**Consultation Response from KC,  
Trees**

**2025/90128 16, Allison Drive, Fartown, Huddersfield, HD2 2RA**

**Erection of single storey extension to dwelling and single storey extension to create dwelling forming annex accommodation associated with 16, Allison Drive, Fartown, Huddersfield, HD2 2RA**

Proposed Site Plan - 1:200

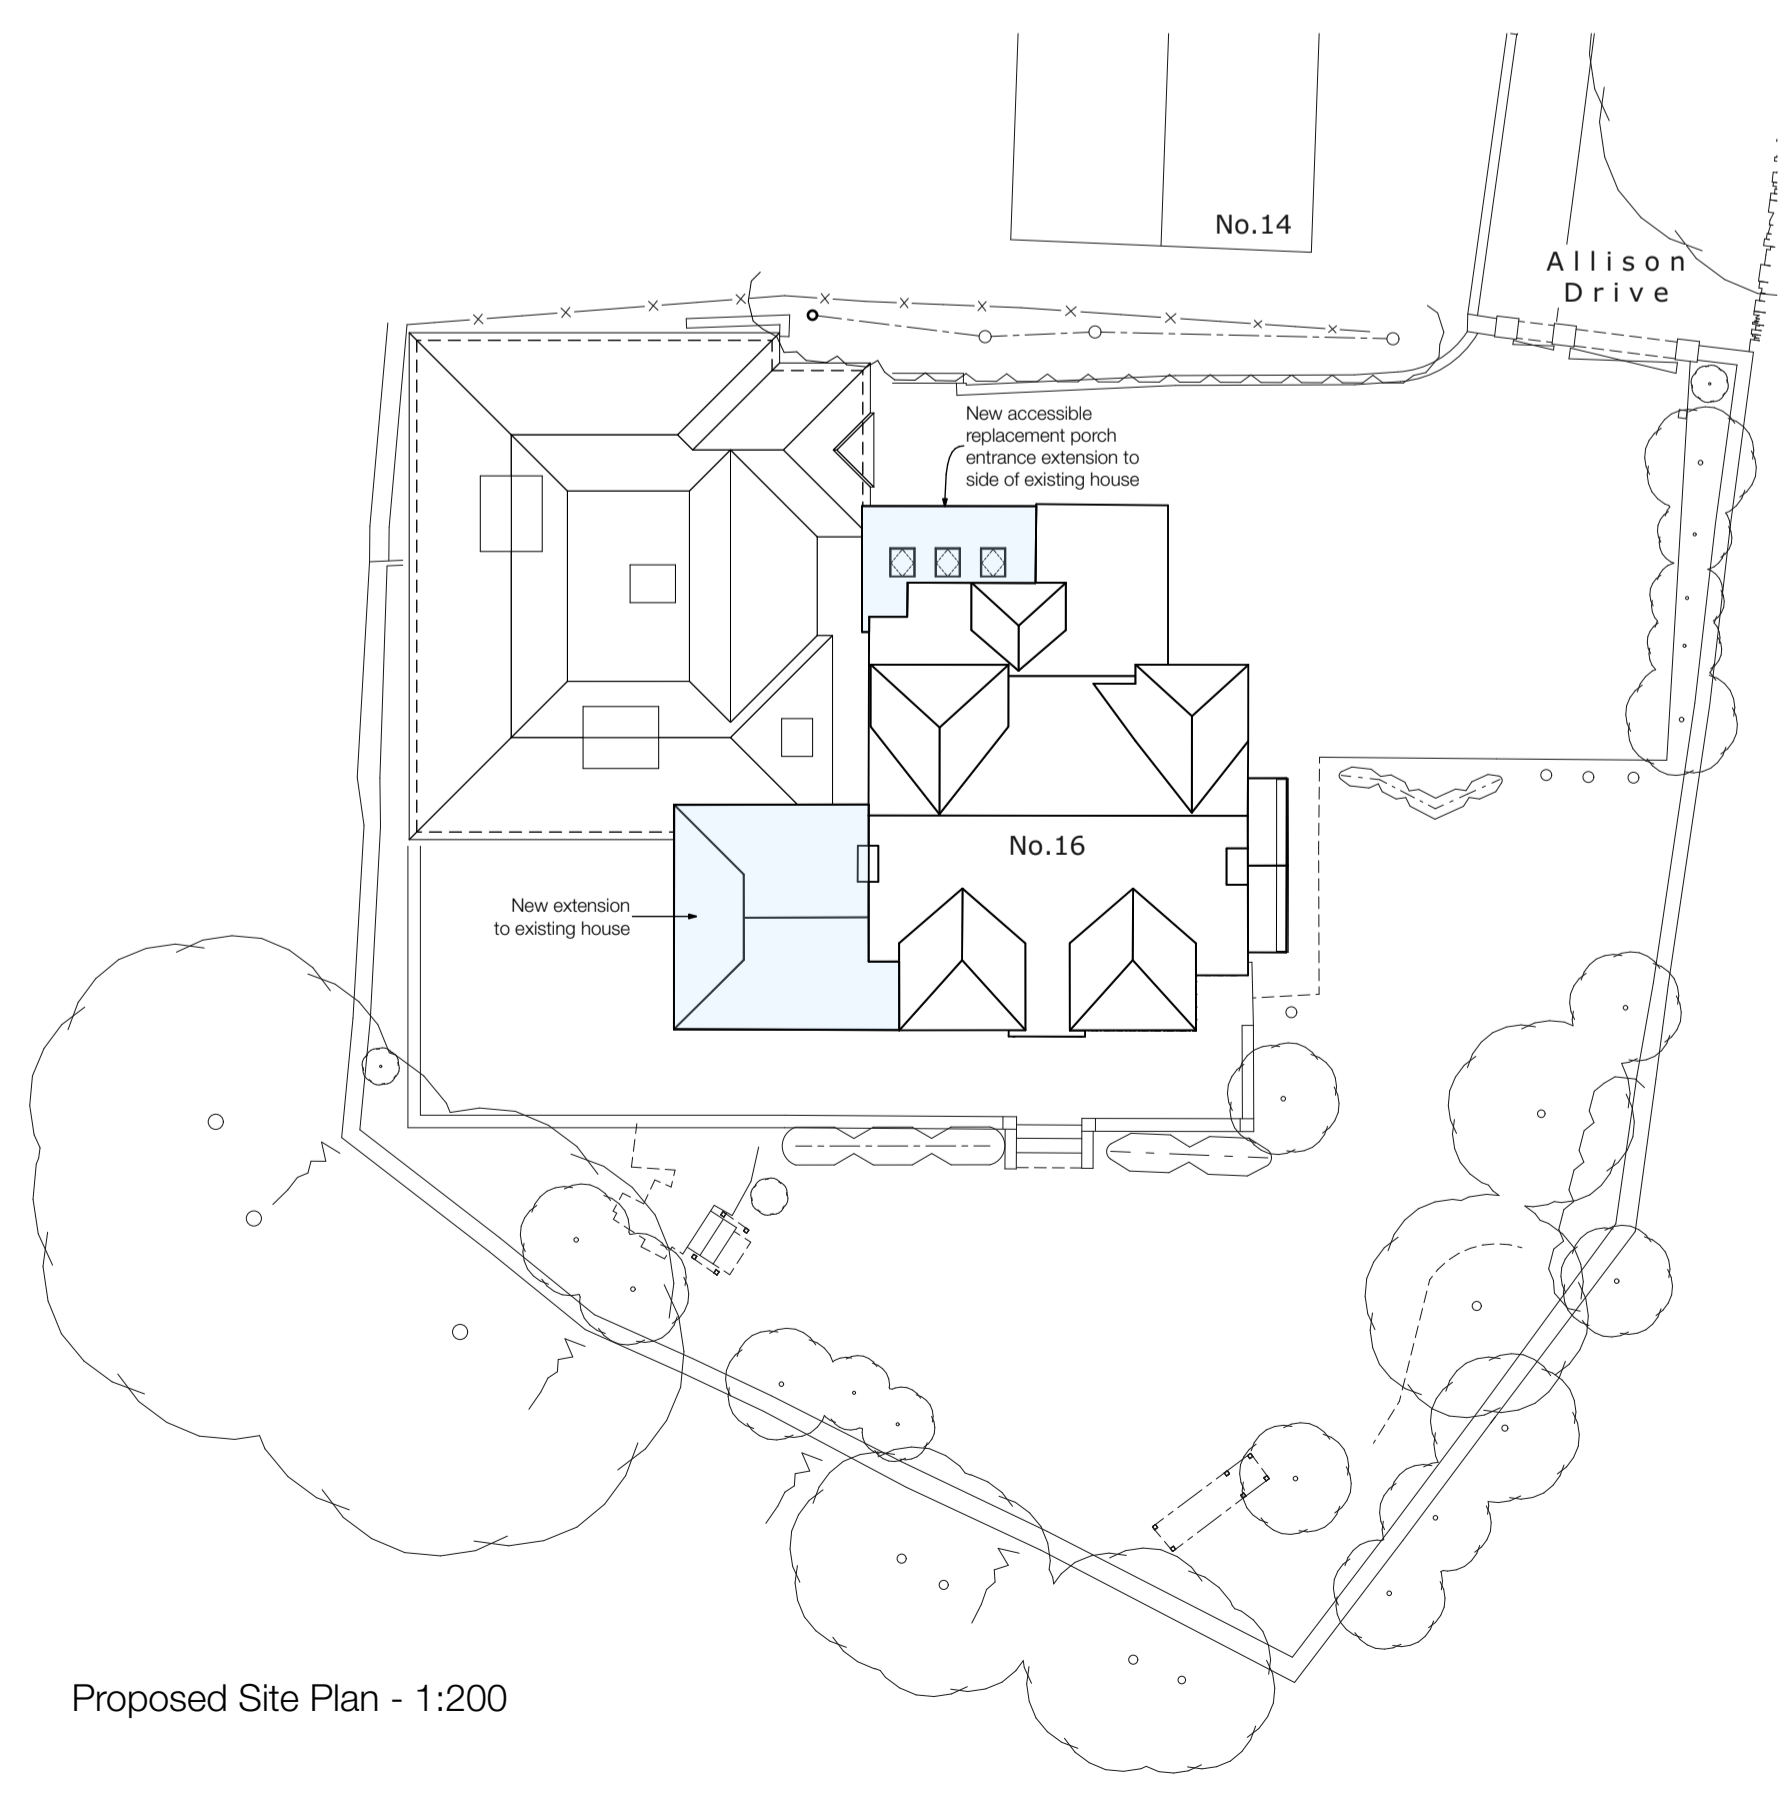
The site has no protected trees but some significant specimens to the southwest corner. The new proposed patio would likely be within the RPA of these trees however due to the presence of existing hardstanding the likelihood of rooting activity is minimal. None of these trees should be affected by the development.

There looks to be three small trees or shrubs to the west of the proposed patio however their removal would not affect public amenity and they are likely category C trees.

There would be no objection to the plans as the impact on adjacent trees would be insignificant.
